Application no: 22/01258/DISC

Location: Phase 7a and 7b, Heyford Park, Camp Road, Upper Heyford, Bicester, OX25 5HD

Transport Development Control

TITLE: TRAFFIC MANAGEMENT PLAN
 COND 51 AND 52

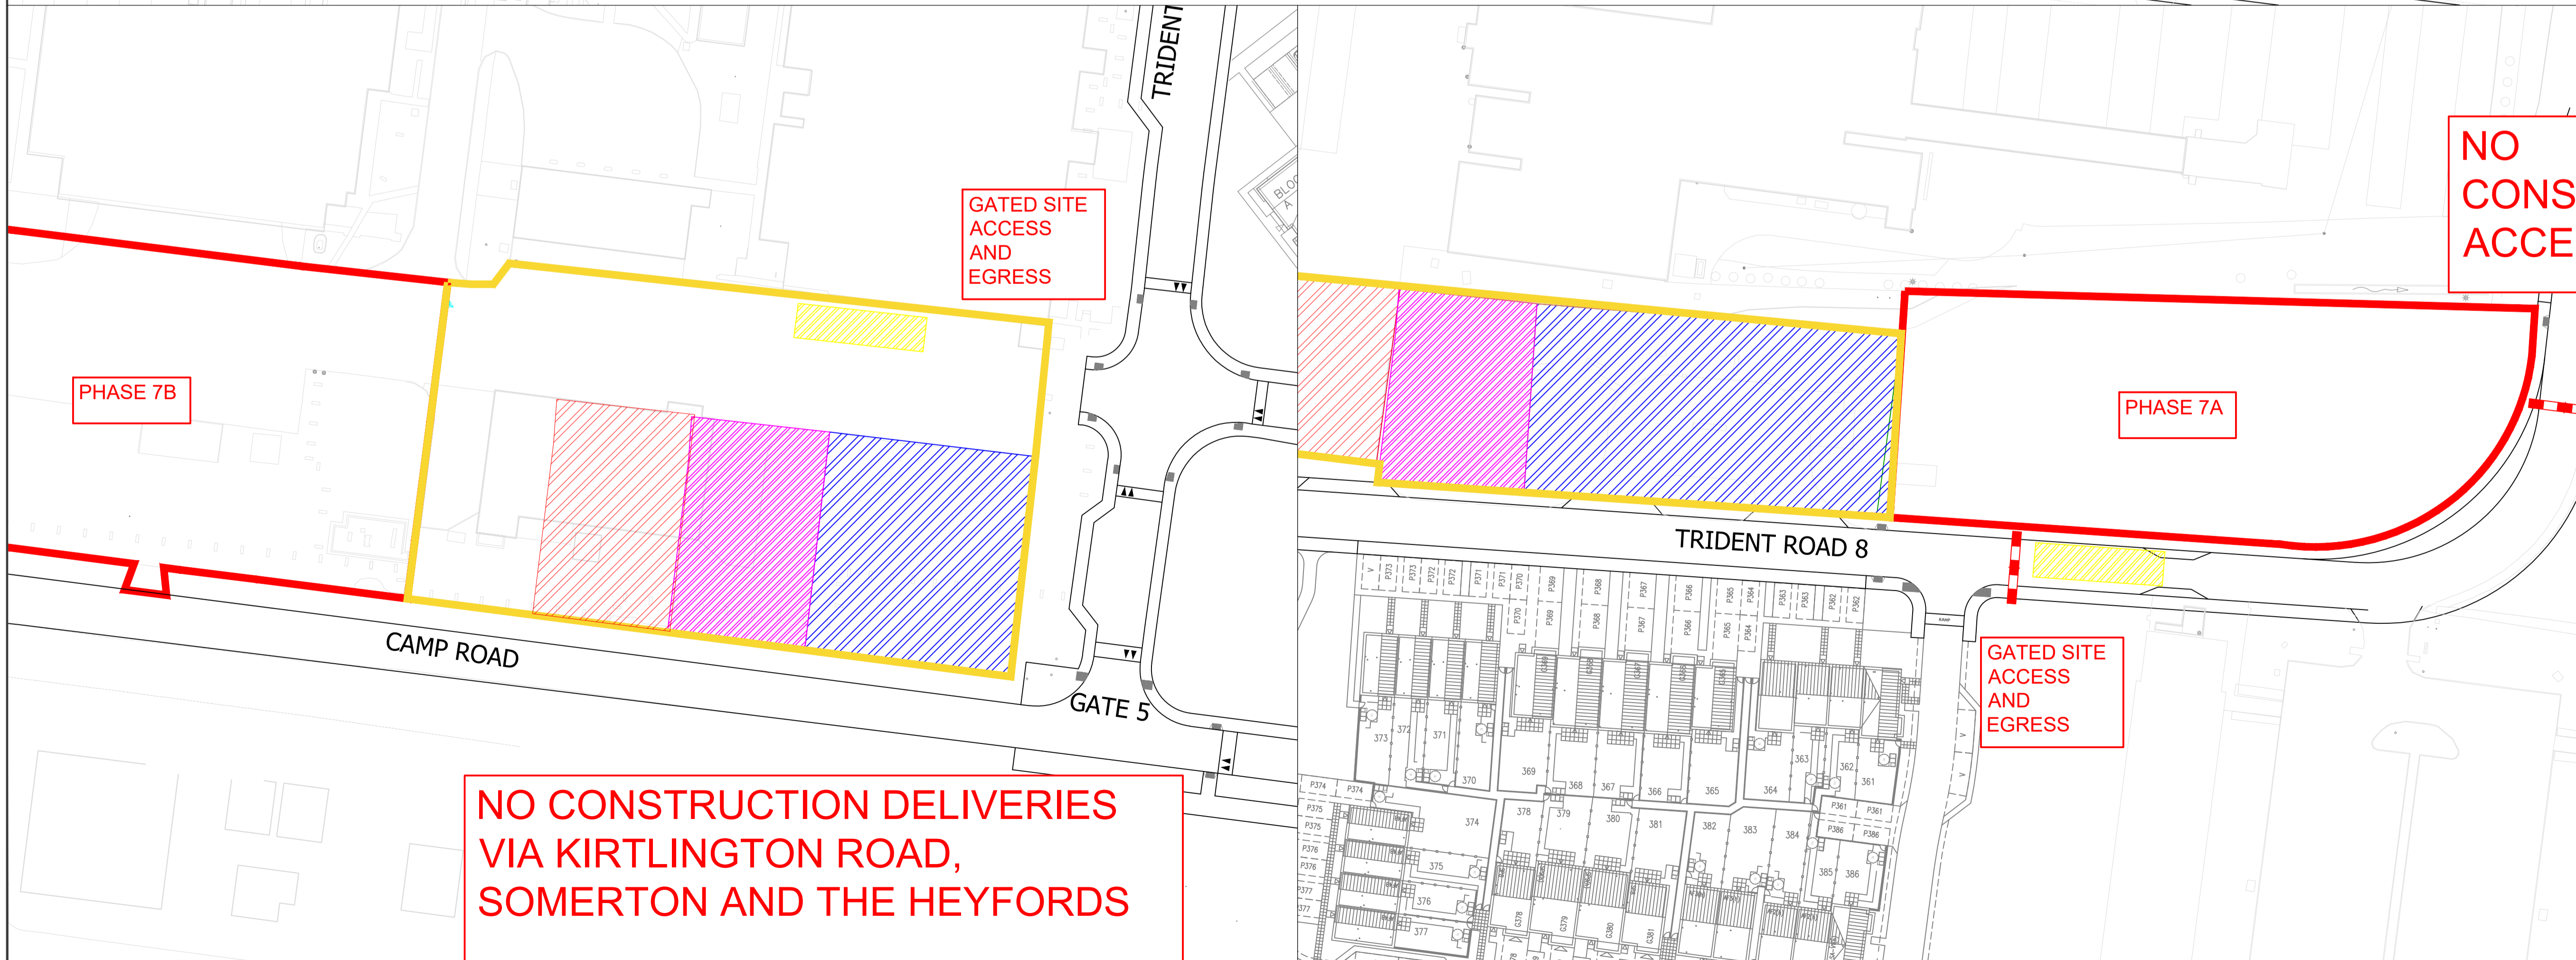
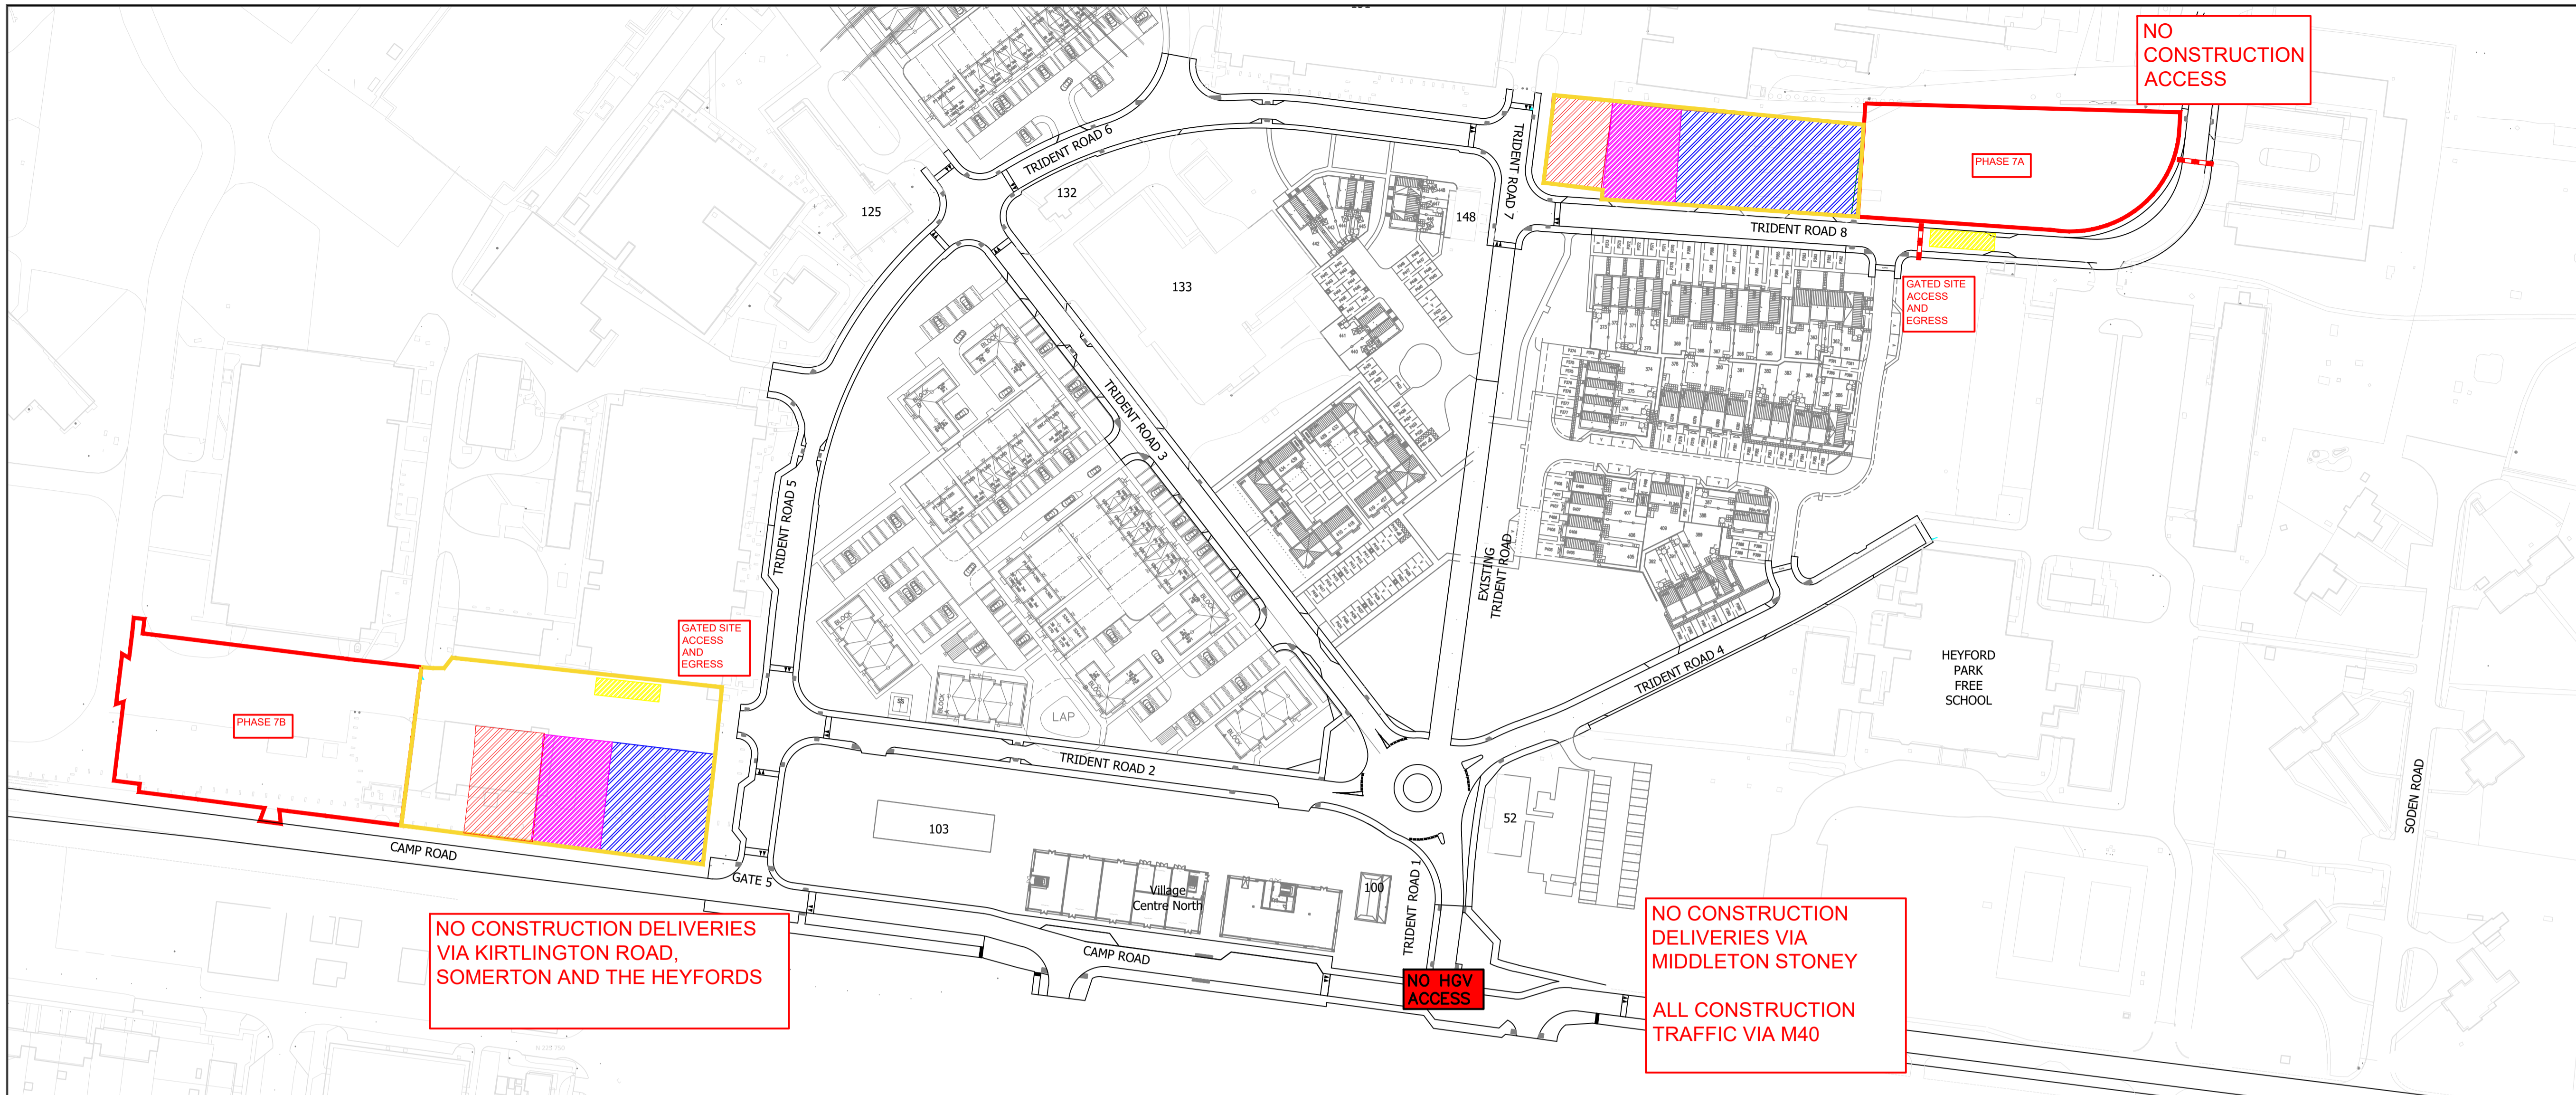
Location and layout of compounds for Phases 7A and 7B are acceptable.

Wheel washing facilities are shown as being suitably close to the gated site access and egress points for phases 7A and 7B.
